REQUEST

Current Zoning: N1-A (neighborhood 1 – A)
Proposed Zoning: MUDD-O (mixed-use development district, optional)

Approximately 20.12 acres bound by the east side of Old Providence Road and west side of Providence Road, north of River Oaks Lane.

The petition proposes a residential development containing up to 745 dwelling units. The site currently contains two single-family homes but is otherwise vacant and mostly wooded.

SHEET NUMBER: RZ2-00

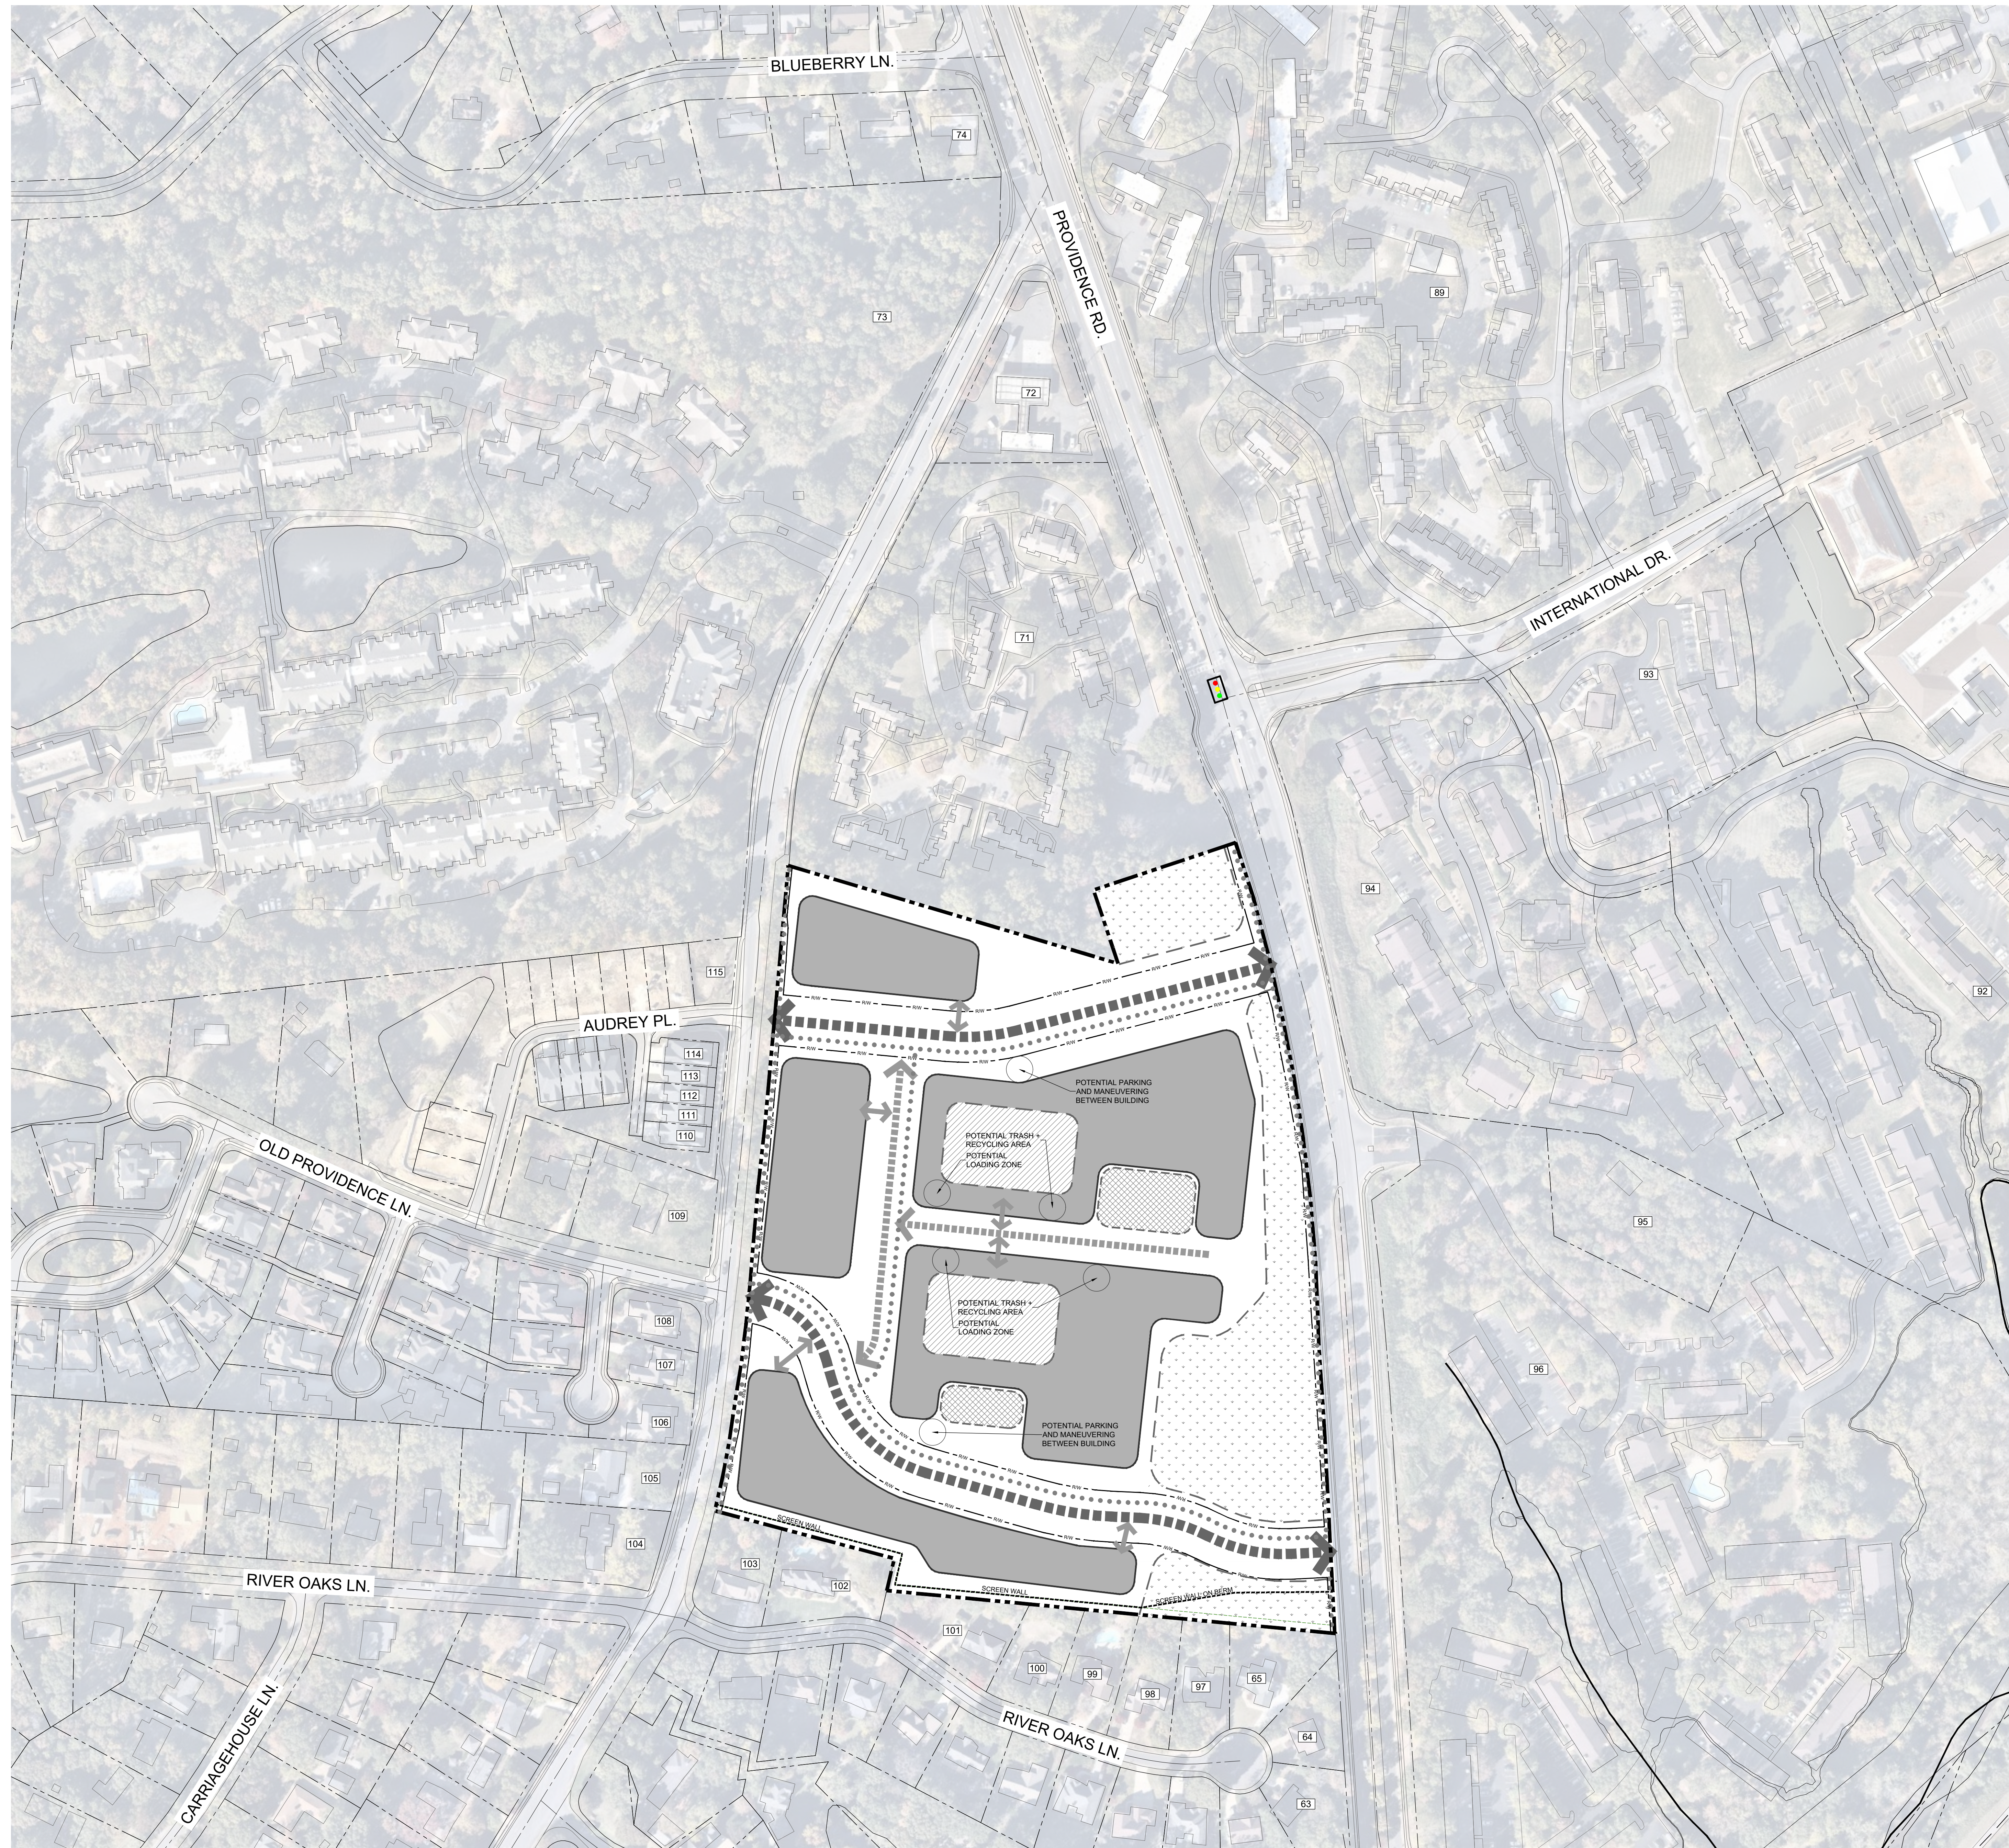
4. Entitlement Services: Coordinate and provide cross-access connection between this the site and the Horizon Properties site to the north, petition 2023-023. **Outstanding**

5. Entitlement Services: Reduce maximum building height in for multi-family buildings to 65 feet. **Outstanding**
6. Entitlement Services: Reduce maximum height of single family attached and detached buildings to 48 feet. **Addressed**

14. Entitlement Services: An approximate location of the pedestrian connection should be shown on the site plan and coordinated with petition 2023-023. **Outstanding**
15. Entitlement Services: Please specify where the proposed 15 detached single-family houses will be located. **Addressed**
